## Appeal Decision

**Appeal Ref: APP/R5510/D/22/3306512**

**132 Northwood Way, Hillingdon, Northwood HA6 1RE**

- The appeal is made under section 78 of the Town and Country Planning Act 1990 against a refusal to grant planning permission.
- The appeal is made by Mr Subhakanta Mohanty against the decision of the Council of the London Borough of Hillingdon.
- The application Ref 12133/APP/2022/1824, dated 6 June 2022, was refused by notice dated 29 July 2022.
- The development proposed is erection of a part single, part double front extension and a single storey rear extension with a raised patio.

Existing & Proposed Ground Floor Plans

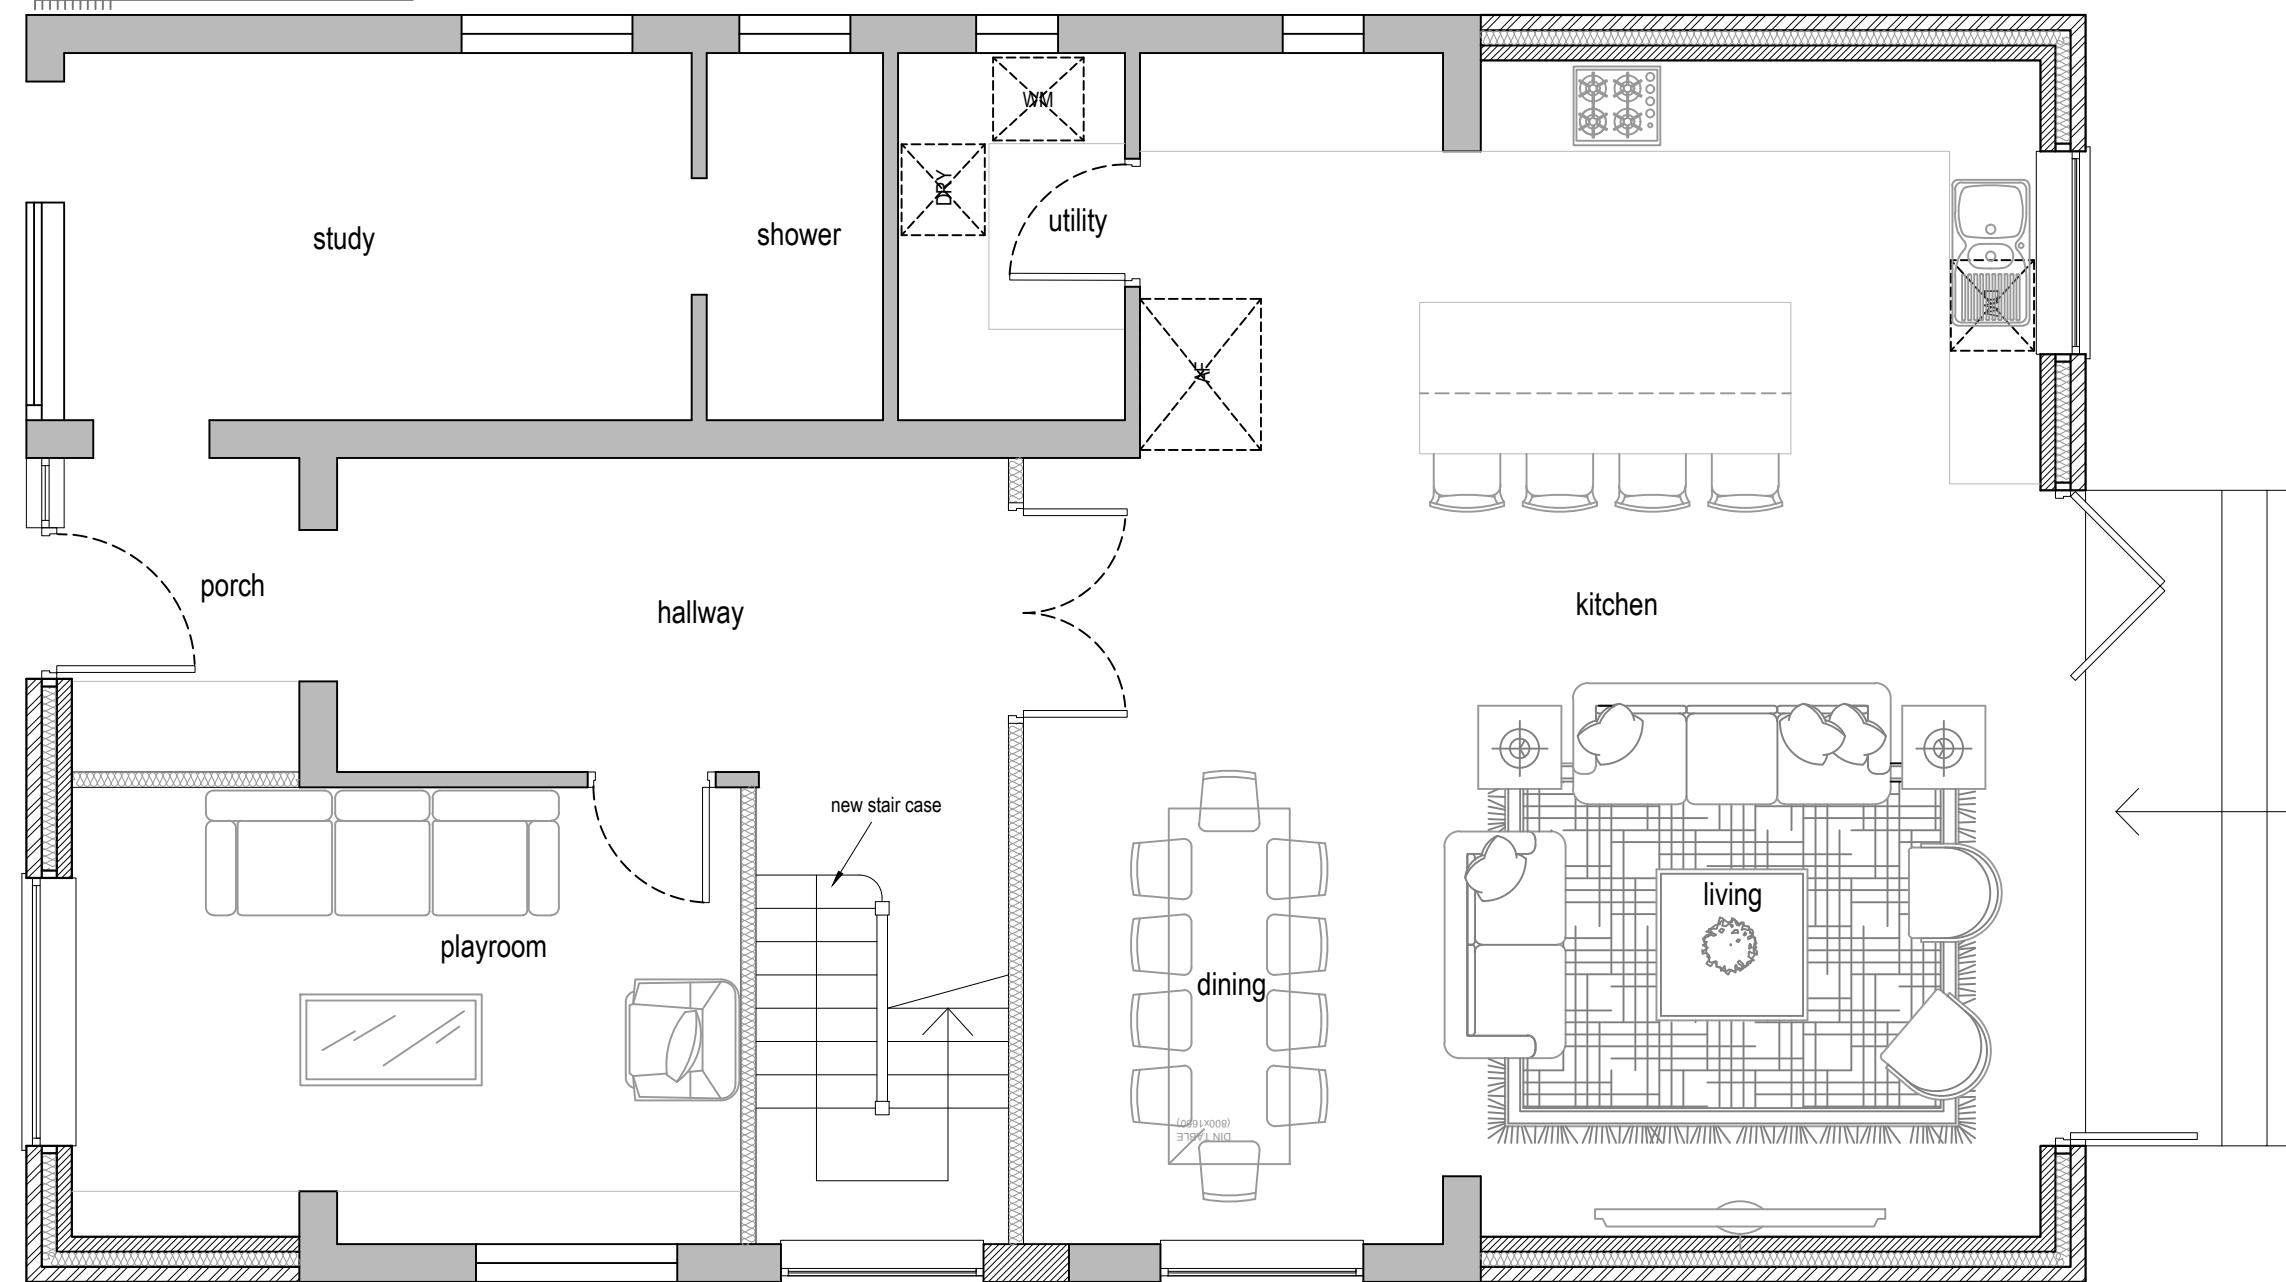
14. The Council suggests that the raised patio proposed to the rear of the dwelling would have a depth of over 6m. From the information before me, it seems that this includes the depth of the steps that would provide access down on to the remaining garden. The steps would be narrow, and would reduce in height towards the rear. Noting also their function and positioning away from the boundaries of the site, I am satisfied that the steps would not facilitate harmful overlooking to neighbouring occupiers.

15. However, the main raised patio area would be of significant height above the ground level to its rear. It would span the full width of the site up to the boundaries with neighbouring dwellings, and even taking the appellant's figures, it would extend from the rear extension for a depth of 4.5m. Although the patio would be slightly lower than that approved under the Permission, it would be of significantly greater depth and width, and in my view would give rise to much greater potential overlooking to neighbouring occupiers.

17. The appellant's photographs do show that there was previously fairly high fencing along the boundary with No 130. This would provide some screening, but without substantive details to demonstrate boundary treatment of sufficient height to prevent views from the patio back towards this neighbour, I cannot be sure that there would be adequate screening to prevent harmful overlooking. Even if I were satisfied that suitable screening would be provided along the boundary with No 130, the details before me indicate that the former boundary treatment to No 134 was much lower. I acknowledge that this would have allowed for a degree of mutual overlooking. However, the depth of the patio and its height above ground level would afford much more direct views down onto the neighbouring garden and back towards the windows and terrace to the rear of the dwelling which in my view would be intrusive, causing a harmful loss of privacy for occupiers of No 134.

Existing & Proposed First Floor Plans

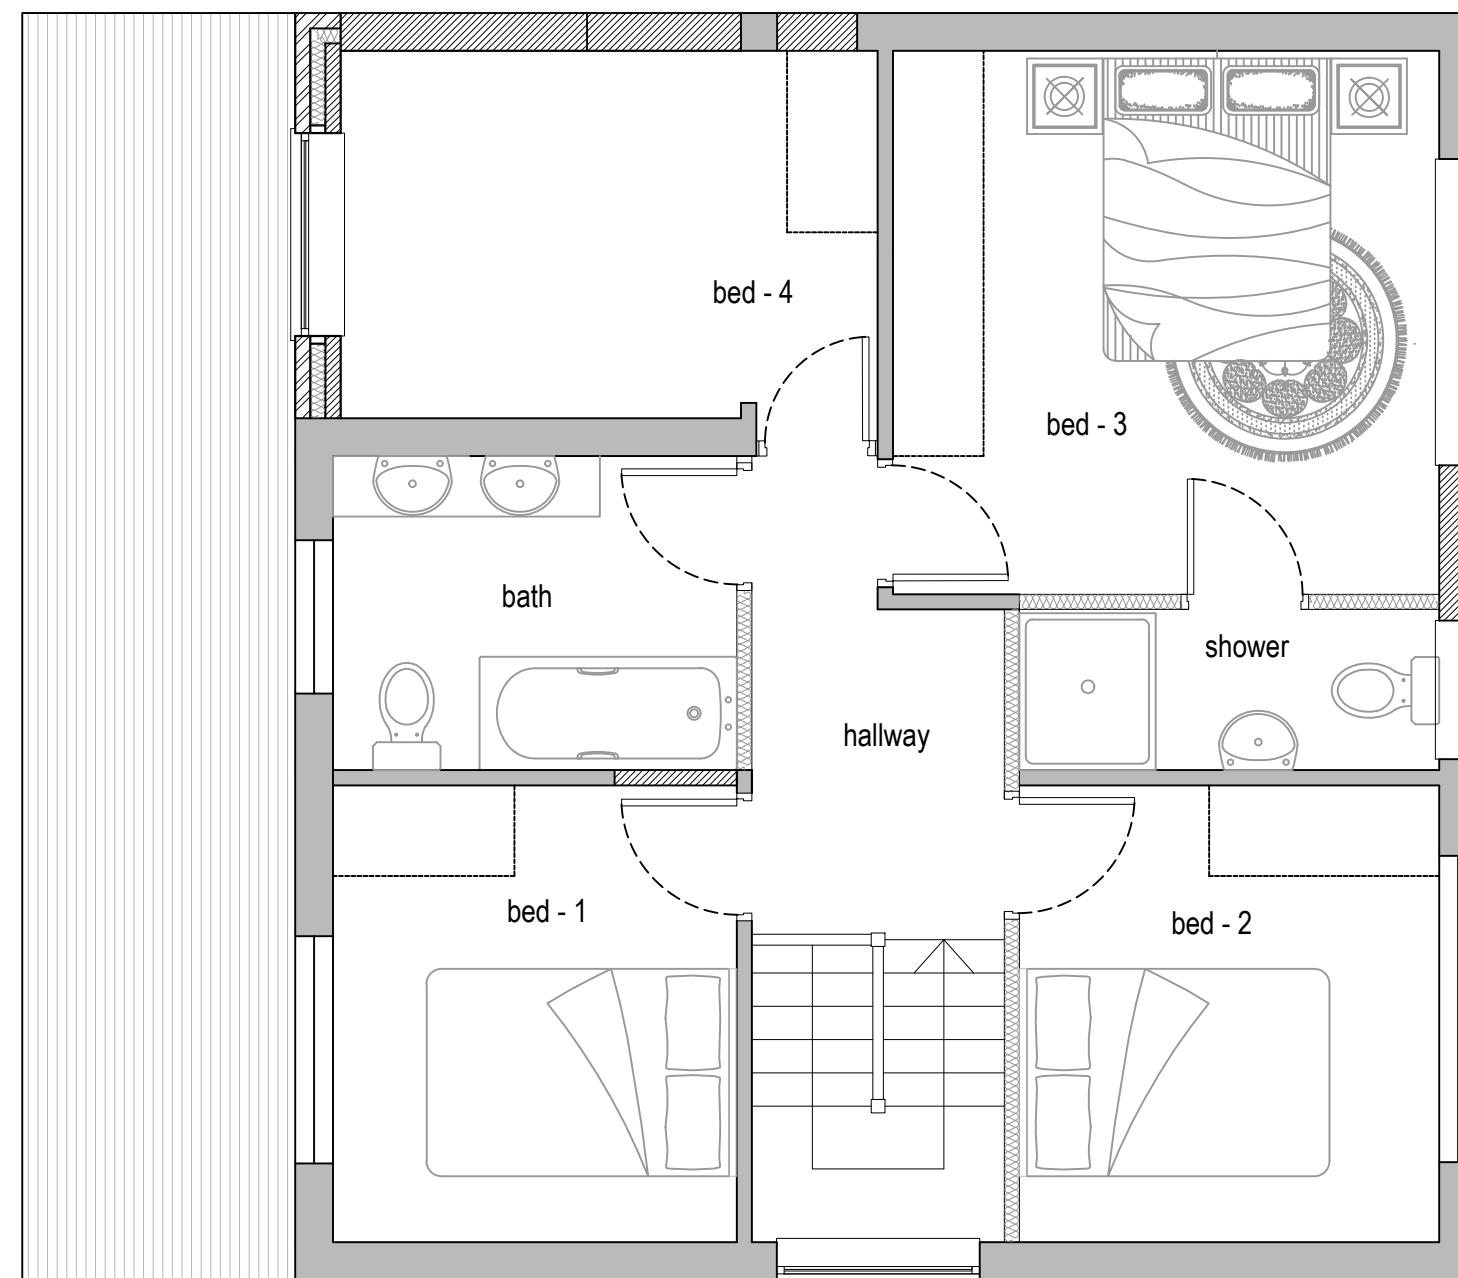
7. The appeal dwelling is a detached property with a stepped front elevation. The side closest to 130 Northwood Way has a two-storey hipped roof forward projection while the first-floor part of the dwelling closest to 134 Northwood Way is of lesser depth. The proposal includes a first-floor front extension to the part of the dwelling closest to No 134 to bring it in line with the front elevation closest to No 130. The main roof would be extended over the development, creating a crown roof form with a flat section. The proposal also includes a single-storey front extension to the part of the dwelling closest to No 130 to match the depth of the deeper ground floor projection closest to No 134.

8. Policy DMHD 1 of the Local Plan Part 2 Development Management Policies 2020 ('the LPP2') states that front extensions extending across the entire frontage will be refused. The proposal would result in development of consistent depth across the entire width of the dwelling at each of the ground and first-floor levels. The appellant comments that the extension will not span the entire frontage of the dwelling, but it is not evident from the information before me that the existing front projections are original features rather than extensions. Even if I were to find that extensions would not extend across the entire frontage though, Policy DMHD 1 also includes a requirement that alterations and extensions to the front of a house must be minor and not alter the overall appearance of the house or dominate the character of the street.

9. The extensions would be set back relative to the front of No 134 and would be on a comparable building line to No 130. As a detached dwelling, the appeal dwelling also differs from its immediate neighbours which are semi-detached properties. Given these factors and the wider variety in the street scene, I am satisfied that while the proposal would notably alter the appearance of the building, the proportions of the ground and first-floor levels of the dwelling and the uniform front building line of each of these storeys across the whole width of the dwelling would not in themselves be inappropriate or visually intrusive.

Proposed Elevations

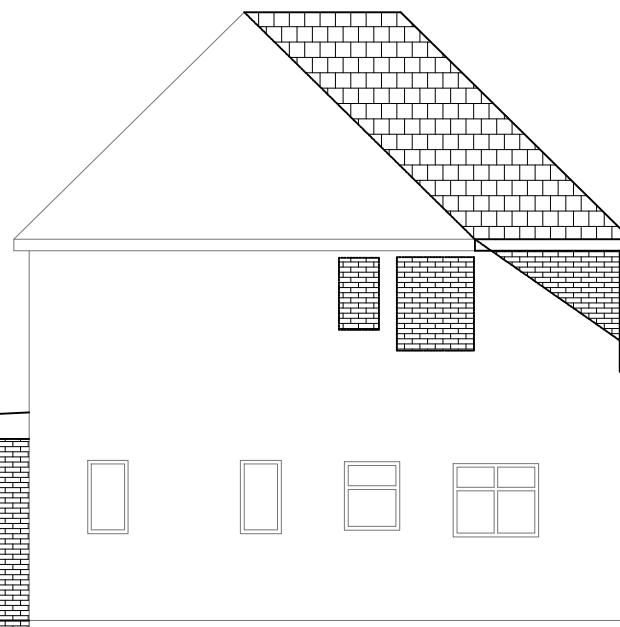
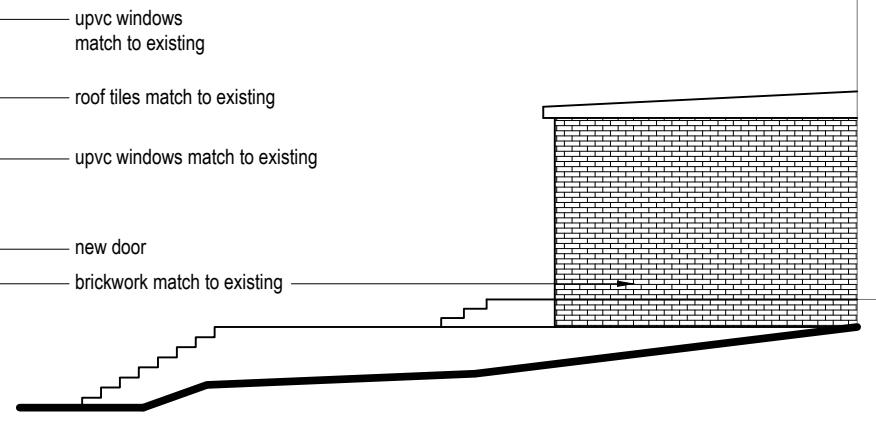
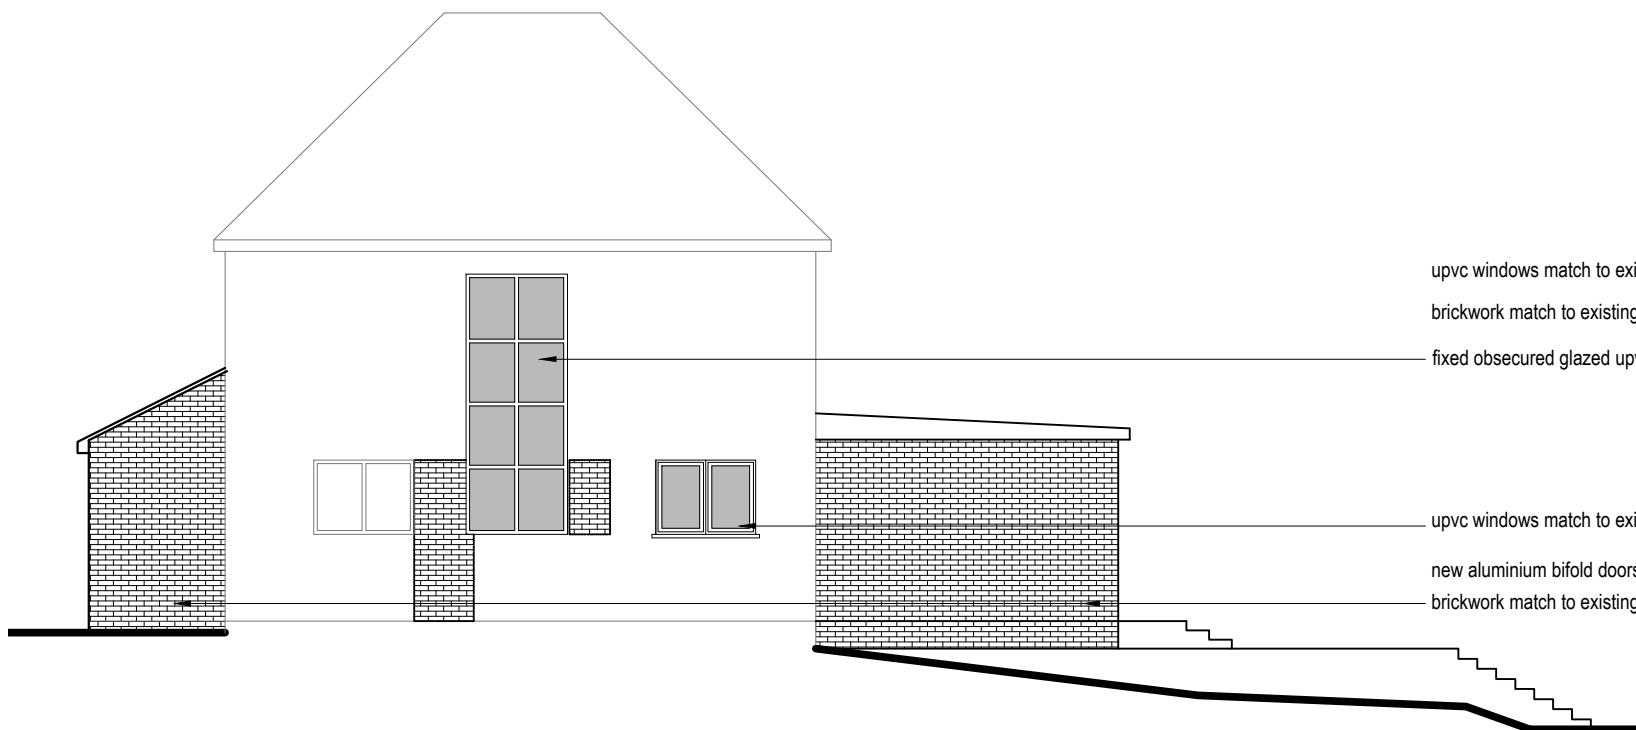
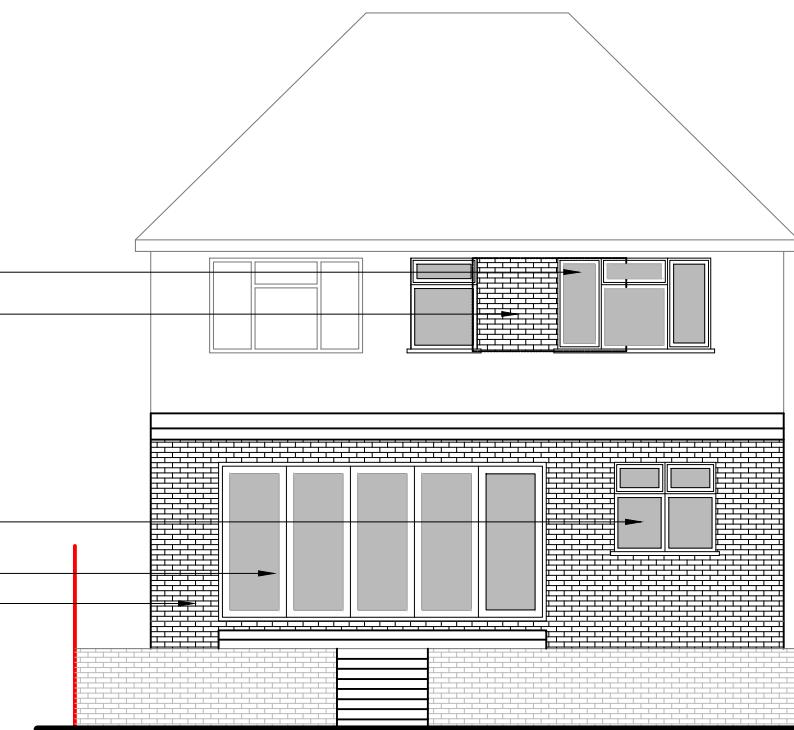
10. However, the crown roof would have a reasonably large flat section relative to the host roof at the same height as the existing ridge, and would add disproportionate bulk to the roof of the dwelling. With or without the additional further works to the roof under the Certificate, this would be detrimental to its architectural integrity and character and would cause it to appear somewhat prominent. Furthermore, it would be an unusual feature in the vicinity of the site. I acknowledge that the dwelling is set back from the street and lower than Nos 130 and 134, but I saw that the existing roof ridge is clearly visible when travelling past the site. Based on my observations, the presence of the crown roof would also be readily apparent. I agree with the appellant that the roof would not dominate the skyline, and I note that the proposal would retain hipped slopes to the side of the crown section. Nevertheless, I find that it

would stand out incongruously against the more typical hipped and pitched roof form of buildings within the wider area. In my assessment, the resulting development would be a discordant feature in the street scene that would detract from the character and appearance of the host dwelling and area.
